Your Ref: OWPC20654
Our Ref: AW/273/18/HH 01-10-2018
Please ask for:
Amber Willard

Formation of a double garage
4 Arun Way Aldwick

1701
05

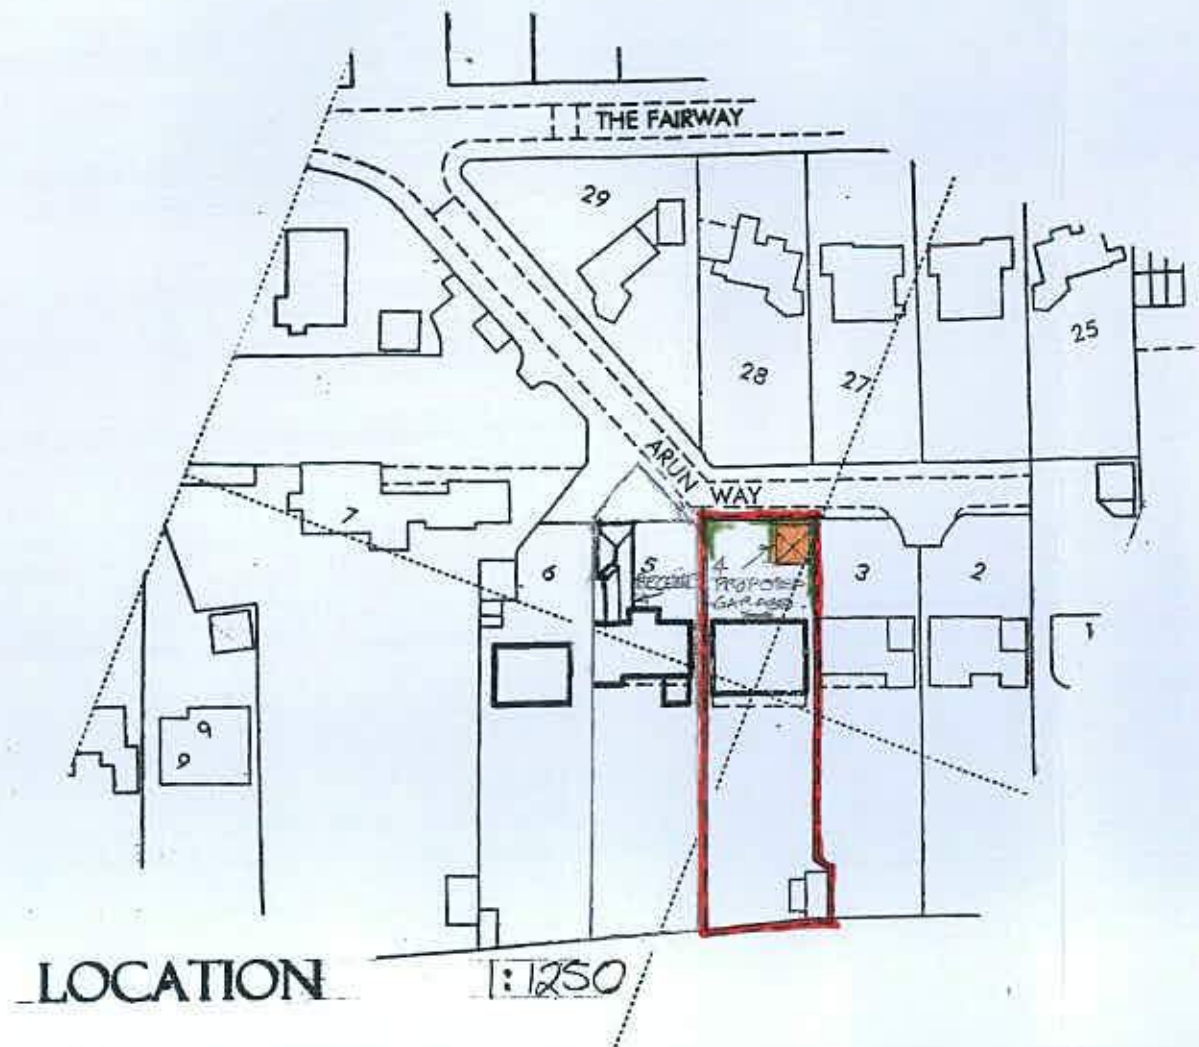
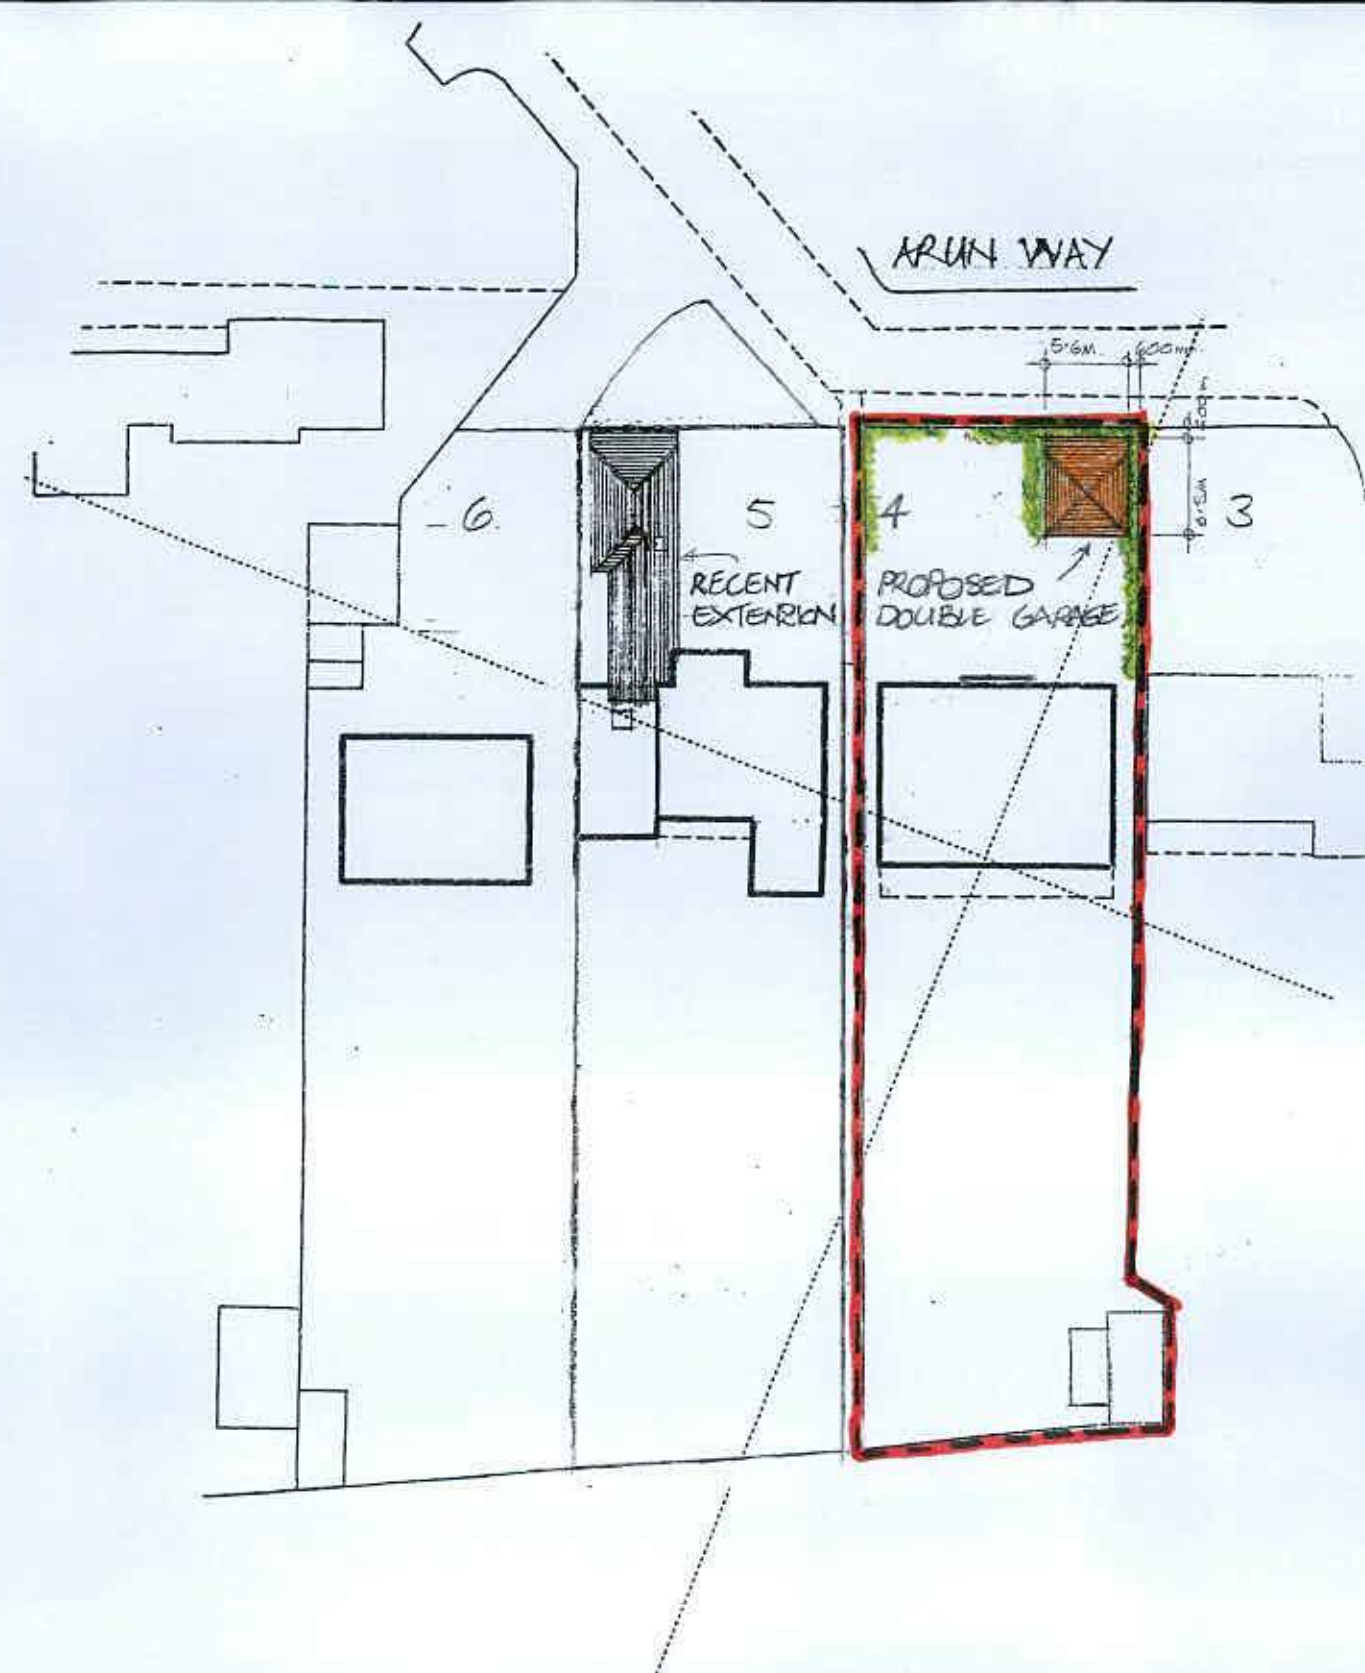
As this garage is rather large (6.5m x 5.6m) and proposed to be sited on the west side of our property (no.3), we feel it will impact significantly on our view of the road coming in and going out and will block evening sun.

If there is to be a garage, our preference would be for it to be on the otherside of the driveway of no.4 by the alleyway down to the beach which is screened by existing mature conifers.

1701
02

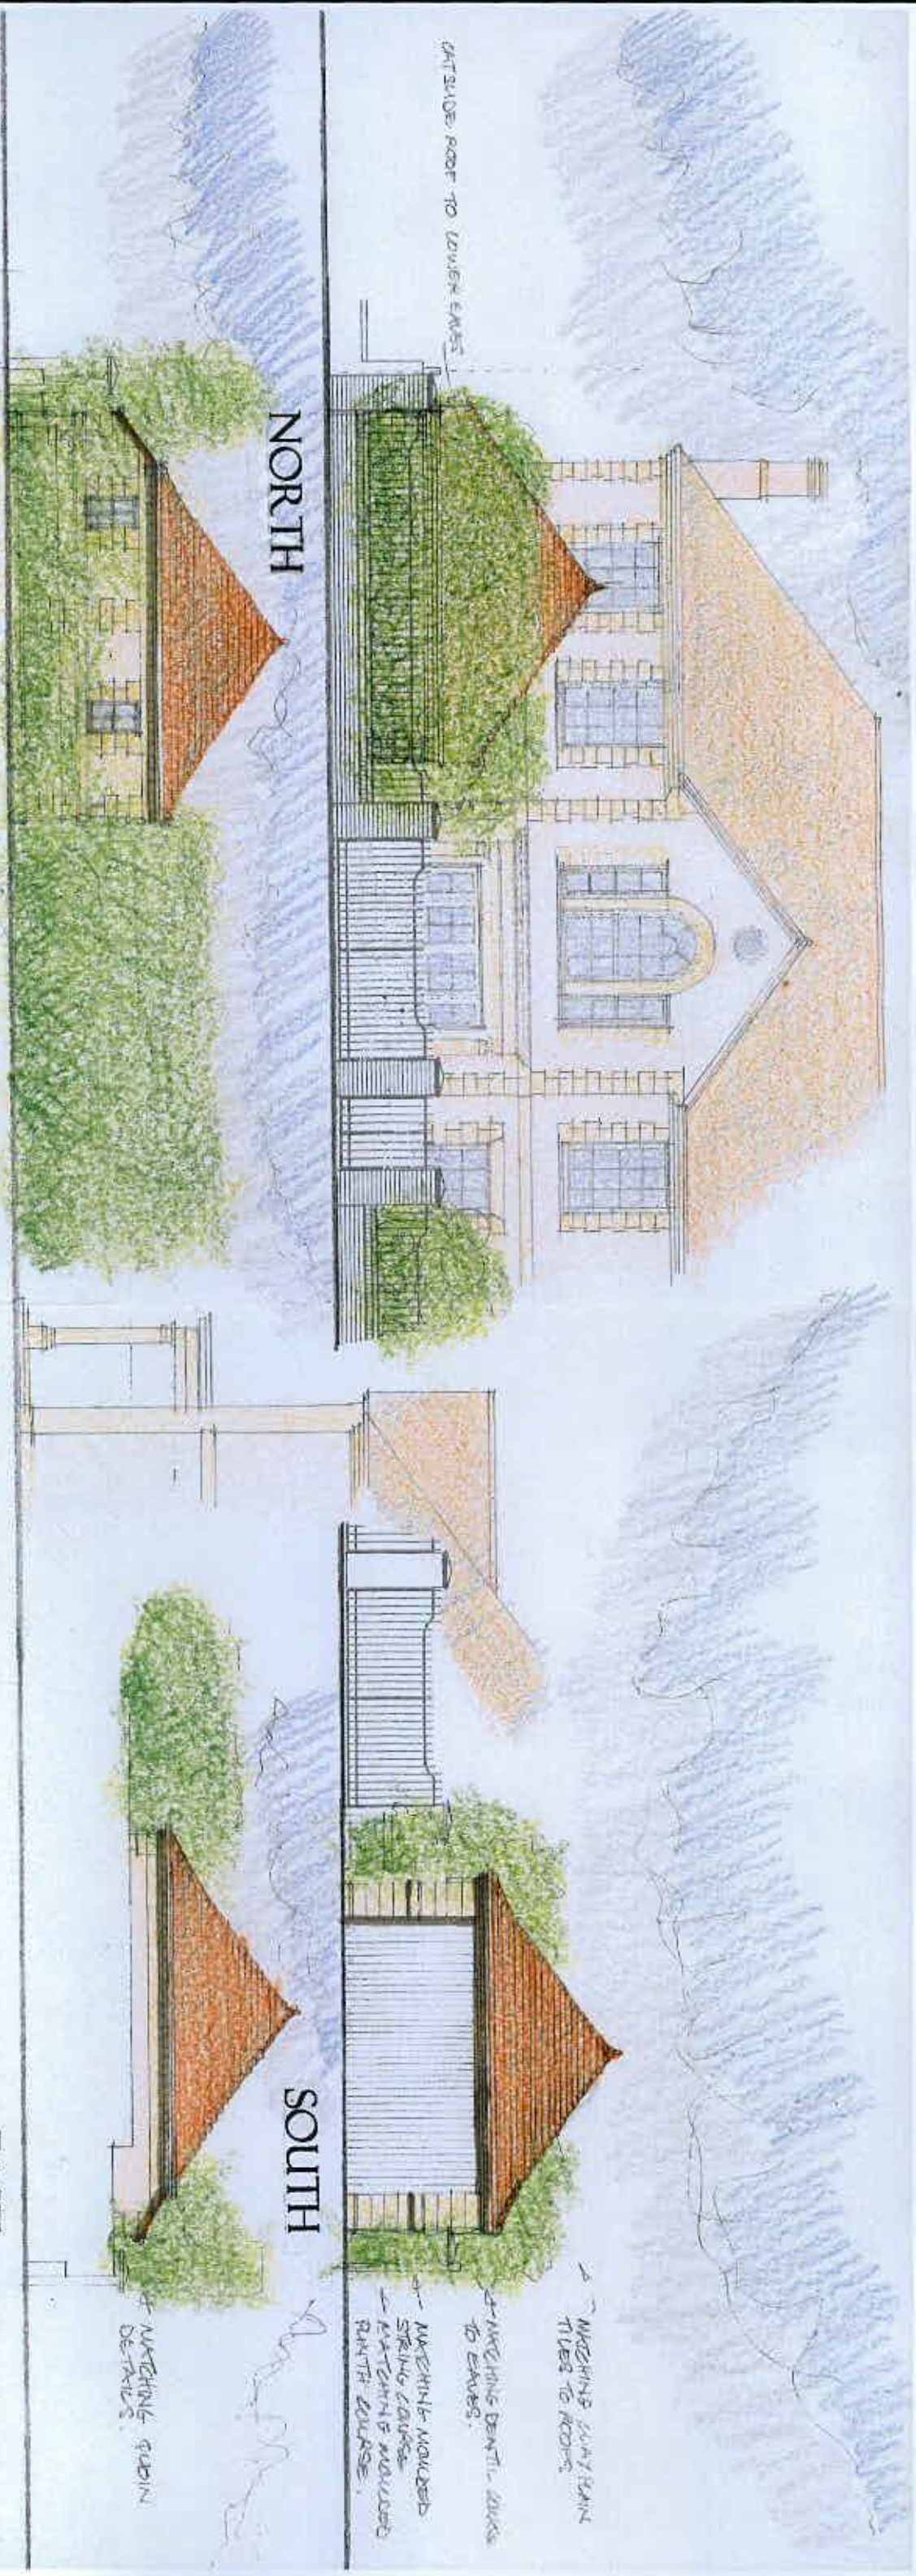
Having looked at the plans I am very concerned about the size and height of the proposed double garage. The height of the walls has not been disclosed but will be greater than the current dividing wall - 1.8m and the proposed height of the roof at its apex will be 4m. That is 2.2m over the dividing wall.
